Our Ref: 3/2024/0395-12

**RE: Land East of Chipping Lane Longridge, Ref: 3/2021/1134
Discharge of Condition 12 relating to Surface Water Drainage**

This is a response to the letter from Lancashire County Council dated 12th June 2024, regarding the application to discharge planning conditions on the aforementioned development (3/2024/0395). The Lead Local Flood Authority have been unable to recommend discharge of Condition 12 on decision 3/2021/1134, based on information or evidence being missing from the submission, and can be found in the following locations:

Title: Developable Areas Plan

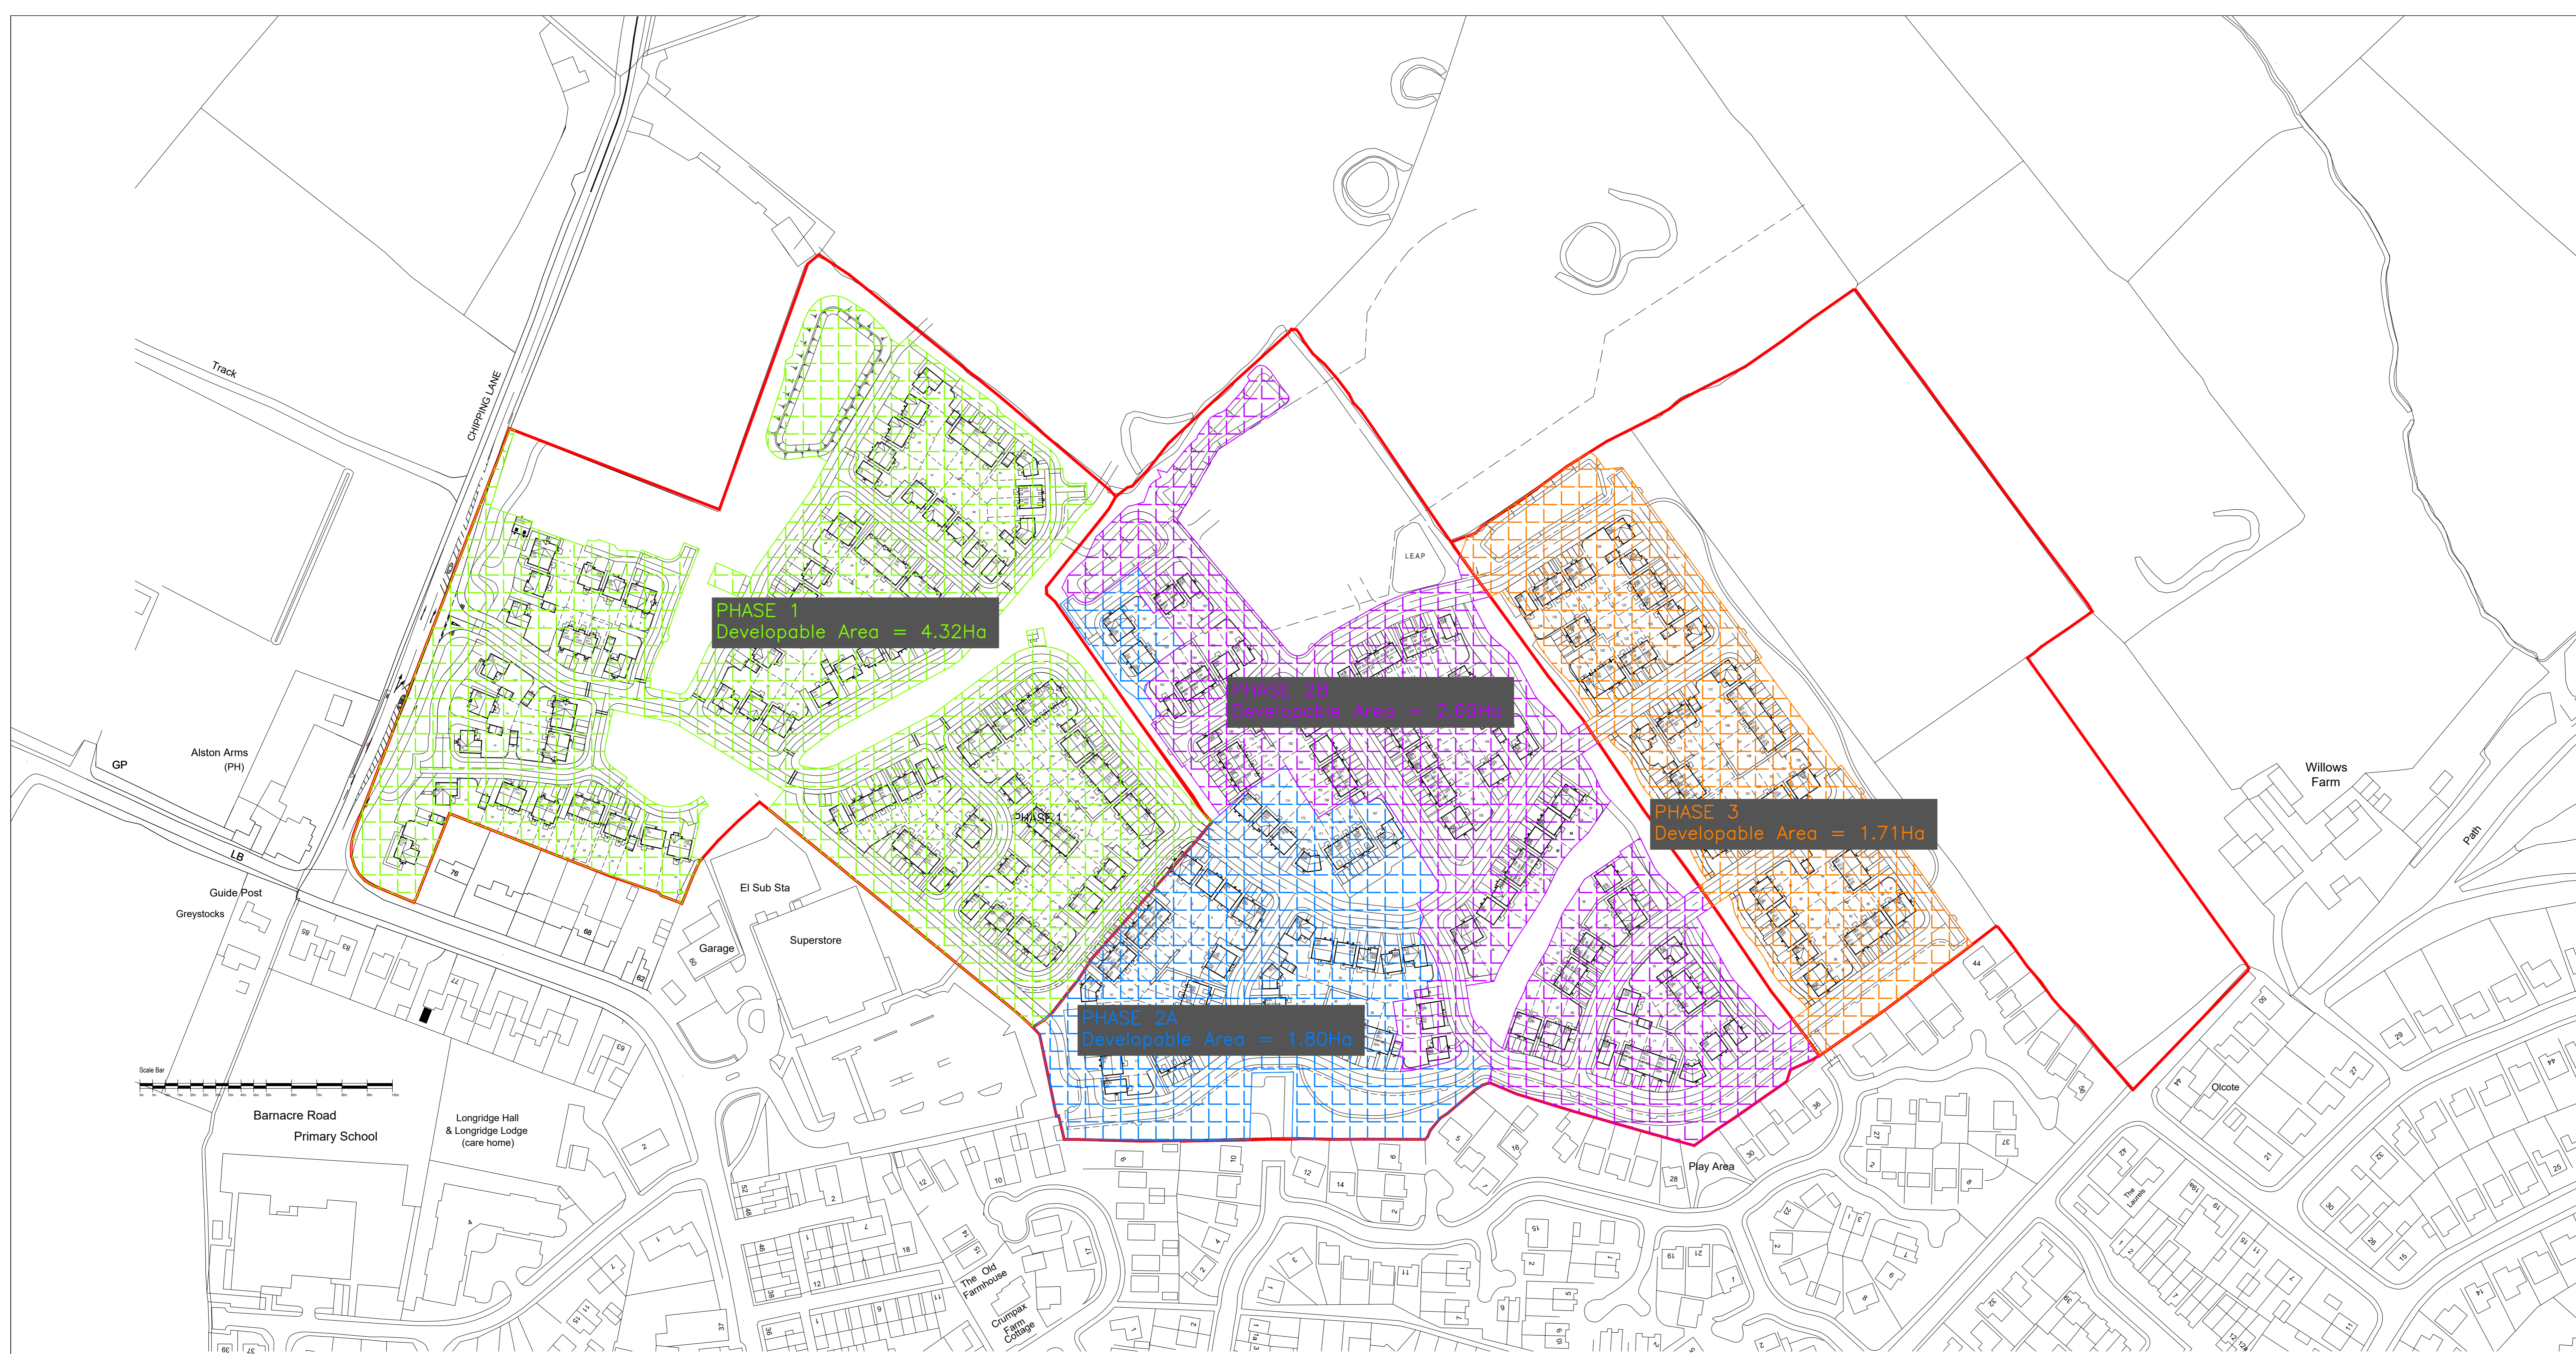
the calculations also show the system exceeding the proposed discharge rate in the 100 year storm calculations.

Please review page 7 of the Condition 12 report produced by Barratt Manchester. The proposed discharge rate is 120.2 l/s into the existing watercourse whereas we are demonstrating an actual discharge rate of 118.1 l/s for the 1 in 100 year + 30% climate change + 10% urban creep. This is a betterment of the overall discharge allowance.
